**WELWYN HATFIELD BOROUGH COUNCIL
EXECUTIVE DIRECTOR - PLANNING, PUBLIC PROTECTION AND GOVERNANCE**

Application No: 6/2022/2079/LAWP
Location: 24 Worcester Road Hatfield Hertfordshire AL10 0DX
Proposal: Certificate of lawfulness for single storey front/side extension with hipped roof
Officer: Mrs Kerrie Charles

Recommendation: Refused

Drawing Title: PROPOSED PLANS AND ELEVATIONS

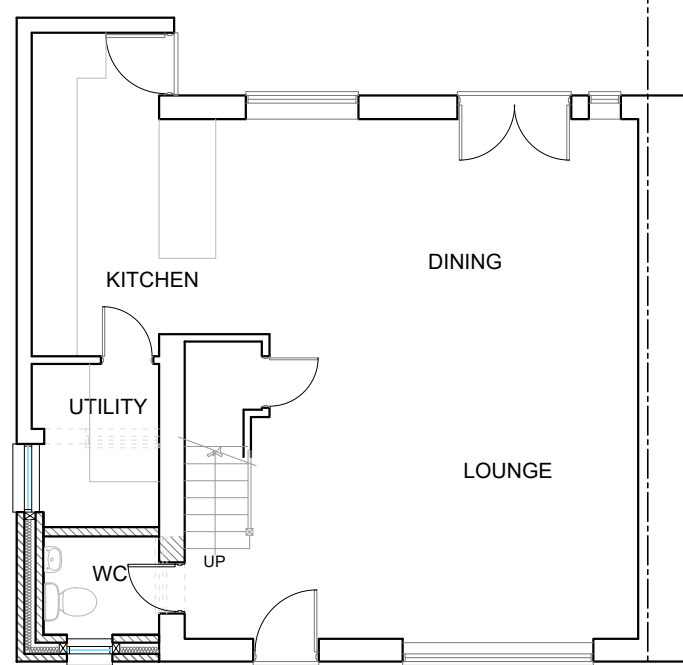
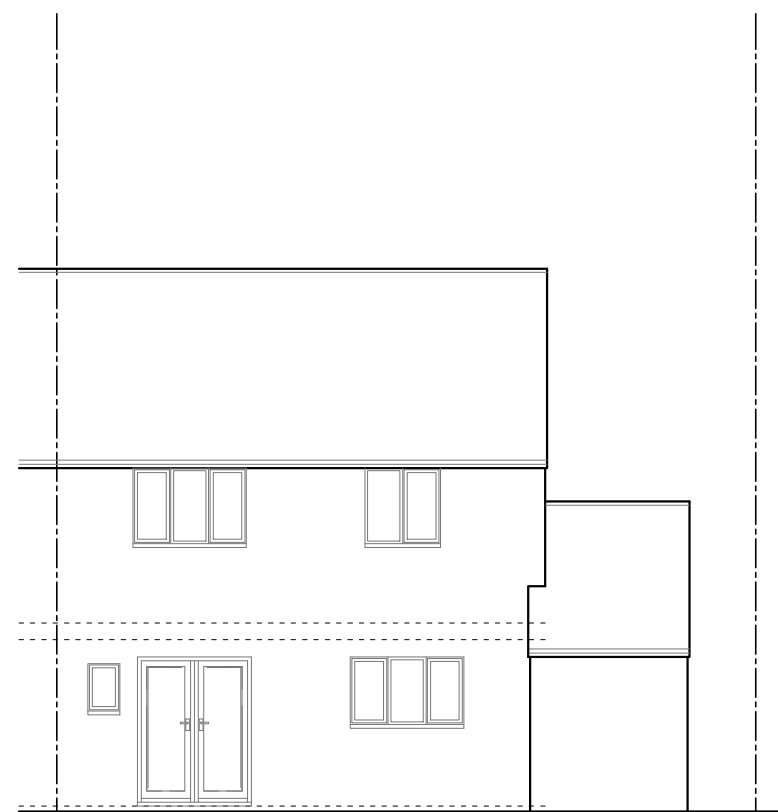
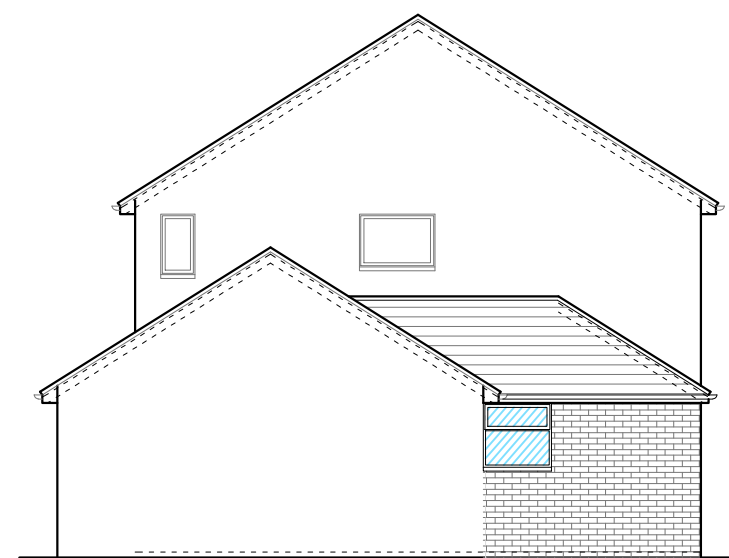
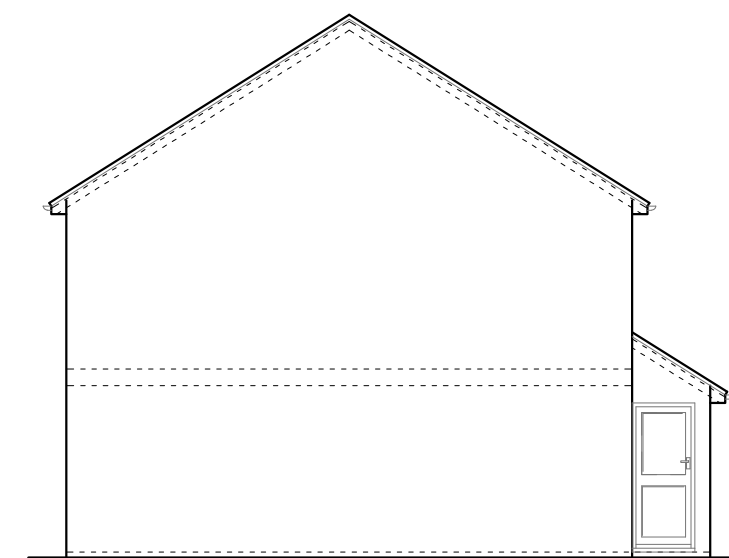
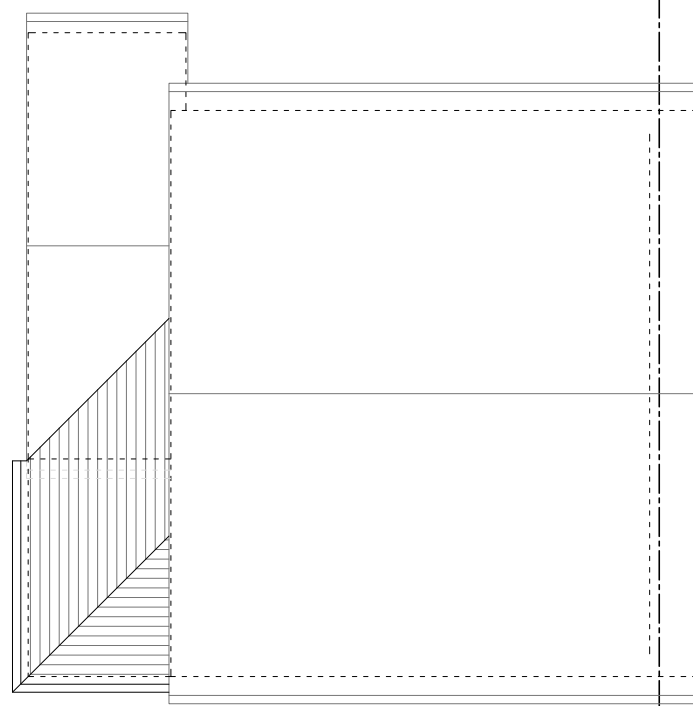
(e) would the enlarged part of the dwellinghouse extend beyond a wall	Y- the	N

which:- (i) forms the principal elevation of the original dwellinghouse; or (ii) fronts a highway and forms a side elevation of the original dwellinghouse	extension would front a highway.

and extend beyond the rear wall of the original dwellinghouse		
(d) any total enlargement (being the enlarged part together with any existing enlargement of the original dwellinghouse to which it will be joined) exceeds or would exceed the limits set out in sub-paragraphs (b) and (c).	N/A	
A.3 Development is permitted by Class A subject to the following conditions:- (a) would the materials used in any exterior work (other than materials used in the construction of a conservatory) be of a similar appearance to those used in the construction of the exterior of the existing dwellinghouse	N	Y

1. The proposed works are NOT permitted development by virtue of Schedule 2, Part 1, Class A of the Town and Country Planning (General Permitted Development) (England) Order 2015 as amended by virtue of the enlarged part of the dwellinghouse extending beyond a wall which fronts a highway and forms a side elevation of the original dwellinghouse. Furthermore, the proposed materials are not confirmed to be of a similar appearance to those used in the construction of the exterior of the existing dwellinghouse.
